2023/0251

Erection of two padel tennis courts with associated building enclosures including canopy roof on former bowling green

Shaw Lane Sports Ground, Shaw Lane, Barnsley, S70 6HZ

02 | SIDE ELEVATION
1:100

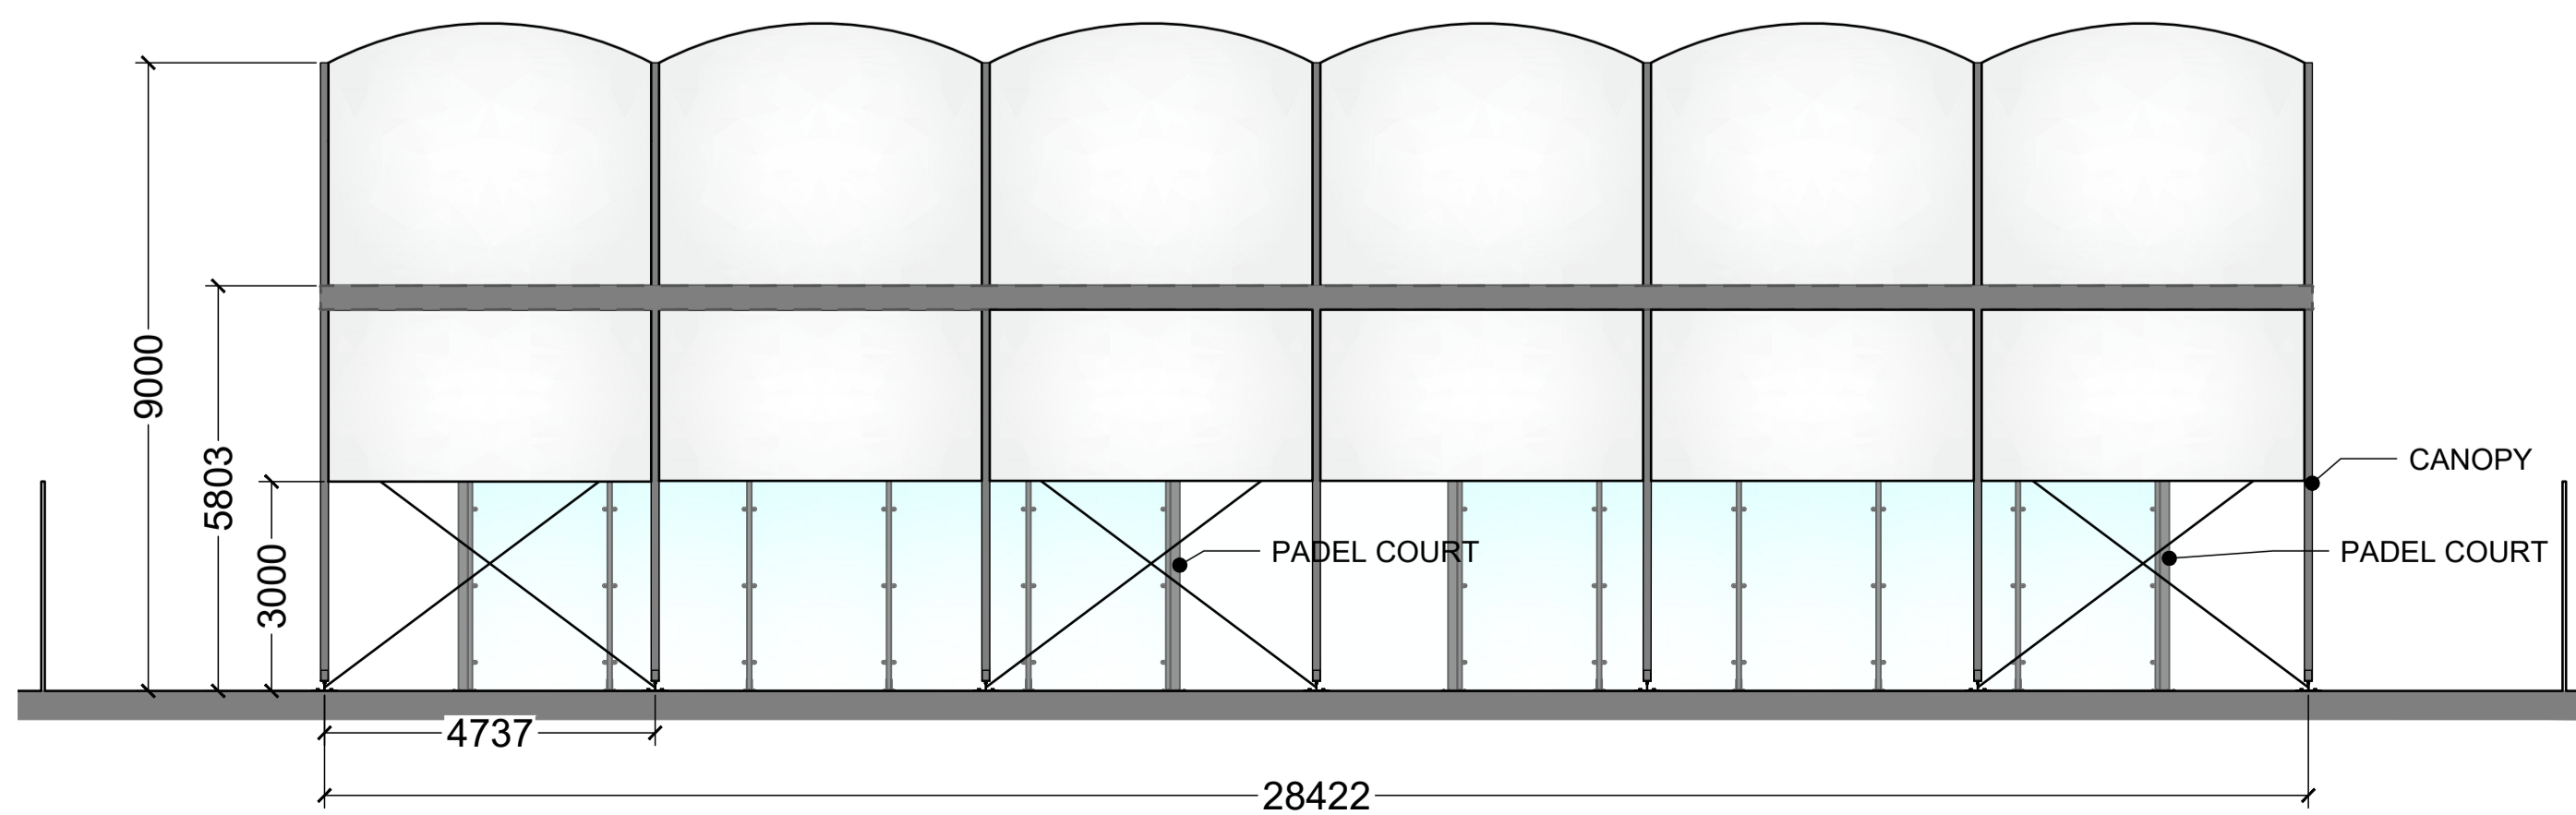
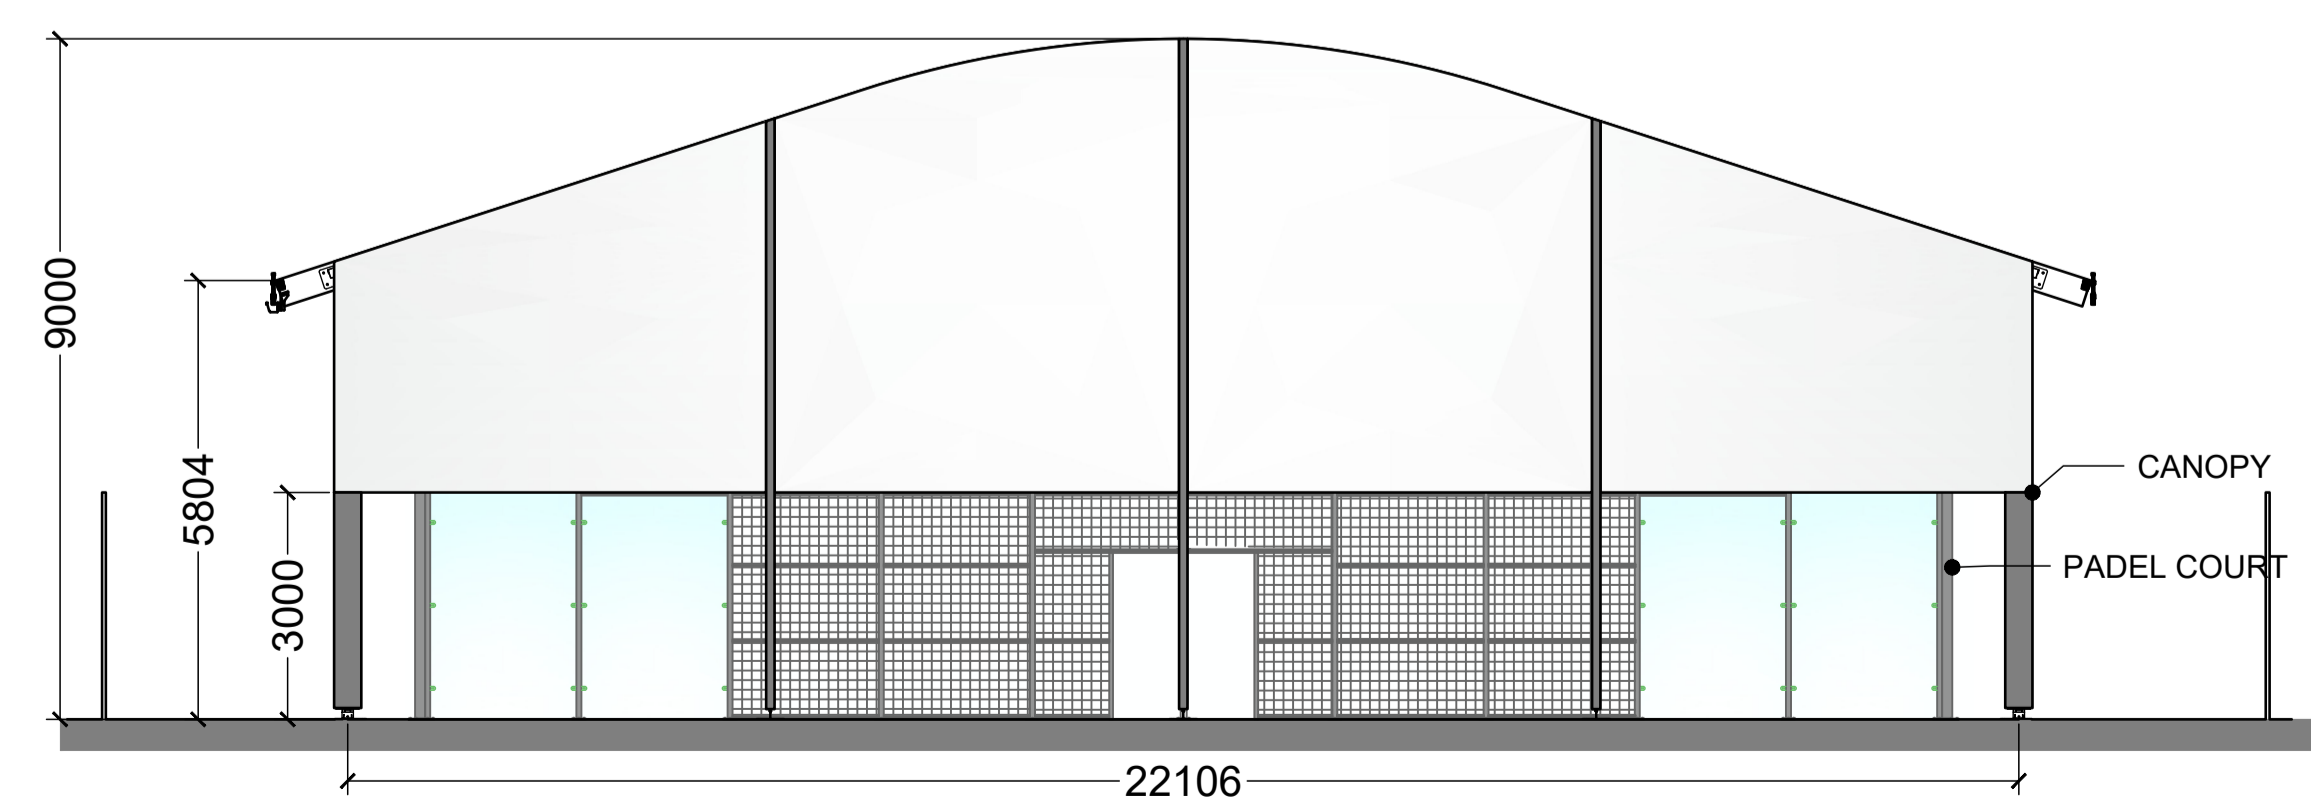
The main visual impact of the proposed development is the erection of a canopy which would be situated on top of the proposed padel tennis courts. The height was initially proposed as 11m which was considered to be excessive, in comparison to the existing buildings on site and the clear, unobstructed views from high rise buildings in the Town Centre. Upon discussion with the agent, there was scope to reduce the height of the canopy but there was a need to have at least an 8.5m clearance above the pitches to allow the game to operate to a sufficient standard. As such, the height of the canopy was reduced to a maximum of 9m. This is a c.19% reduction in height which will reduce the bulk and massing of the facility, whilst allowing for the sports facility to operate to the required standard. The canopy will still be visible from high rise buildings in the town centre, and will be the tallest building on the site, but the height is much more palatable than the initial scheme and will blend into the sports village more successfully.

The most visible part of the application would undoubtedly be the canopy over the proposed courts. The initial scheme showed that the canopy would have a height of 11m, which was considered to be excessive in height and was asked to be reduced. The lowest height to allow clearance for the game to be played to a sufficient standard is 8.5m, and the canopy was therefore reduced in height to 9m. This would still result in the canopy being the largest structure within the sports village and it will still be a visible presence when physically on the site, as well as being visible from high rise buildings in the Town Centre. However, a height of 9m to the highest point is not considered to be unreasonable, especially considering that the roof is pitched/arched, with a sharp drop to the eaves which are 5.8m in height. For comparison, the neighbouring building on site features a very shallow roof with a maximum height of 6.5m, and a height to the eaves of 6m. The site is also well screened from the surrounding streets with trees to the immediate rear, obstructions by existing buildings on site, and also the distance (250m) to the entrance to the site from Shaw Lane. The amended design is considered to be appropriate.
